From: Mark Chisholm [REDACTED]
Sent: 16 October 2019 16:01
To: Zac Denton <Zac.Denton@arun.gov.uk>
Subject: Re: M/73/19/HH - 7 Sea Way, East Preston

This email is regarding the application for the erection of a single storey outbuilding at the above application site.

Garden studio & washroom

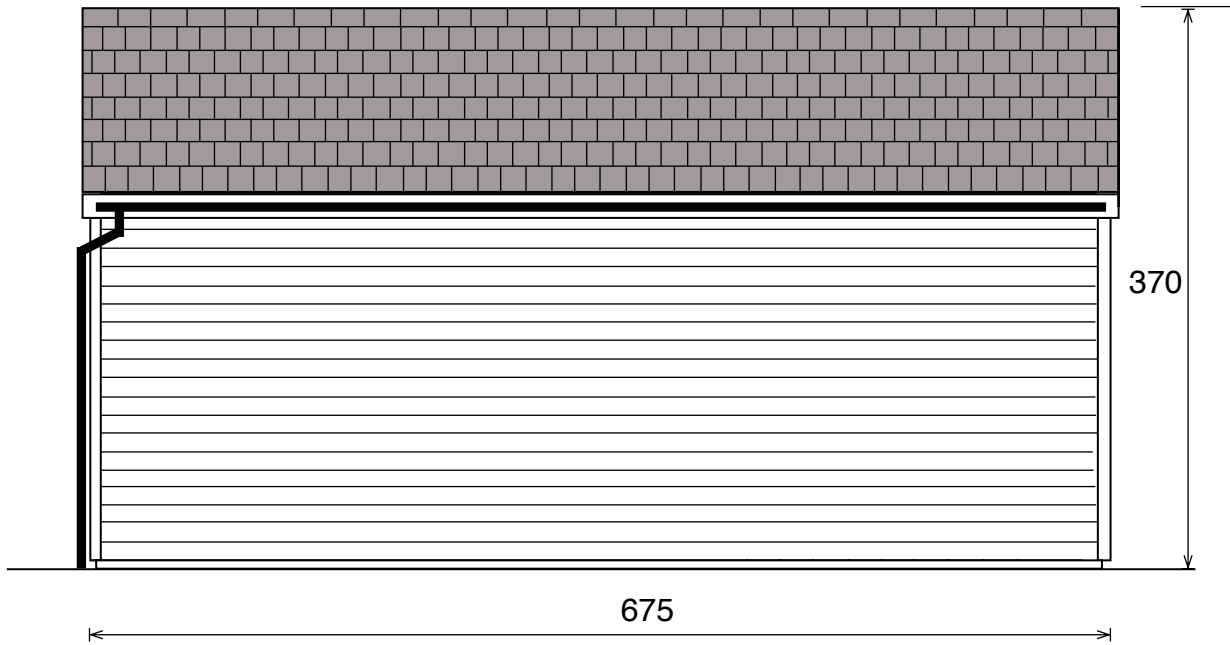
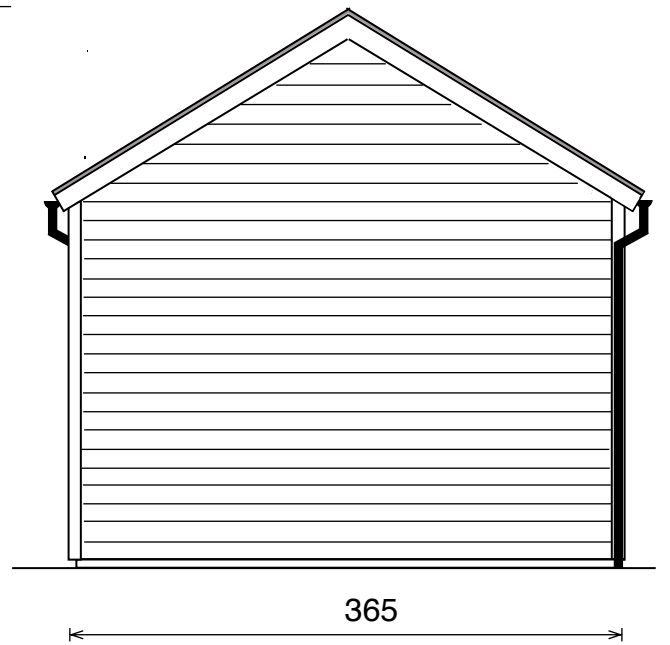
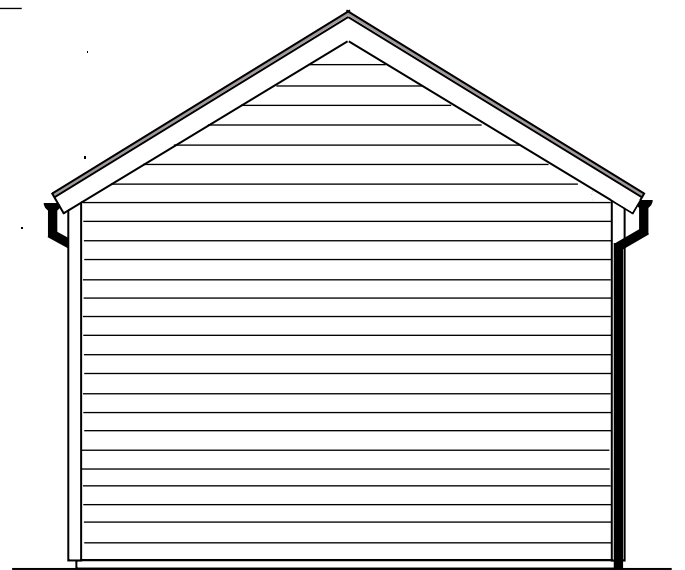
As it stands, the application is not looked upon favourably, as a result of its scale allowing for there to be views of the proposal from the street scene. The proposal is considered to be ugly and unattractive due to its proposed materials.

I am emailing to ask if you would consider altering the proposed materials, as it is felt that more sympathetic materials may remove the current issues with the proposal.

Hi Zac, following our conversation this morning, I've attached a revised scale drawing showing a slate roof rather than sheet steel. I understand that this will now be put out for consultation. Could you estimate when a revised decision date will be?
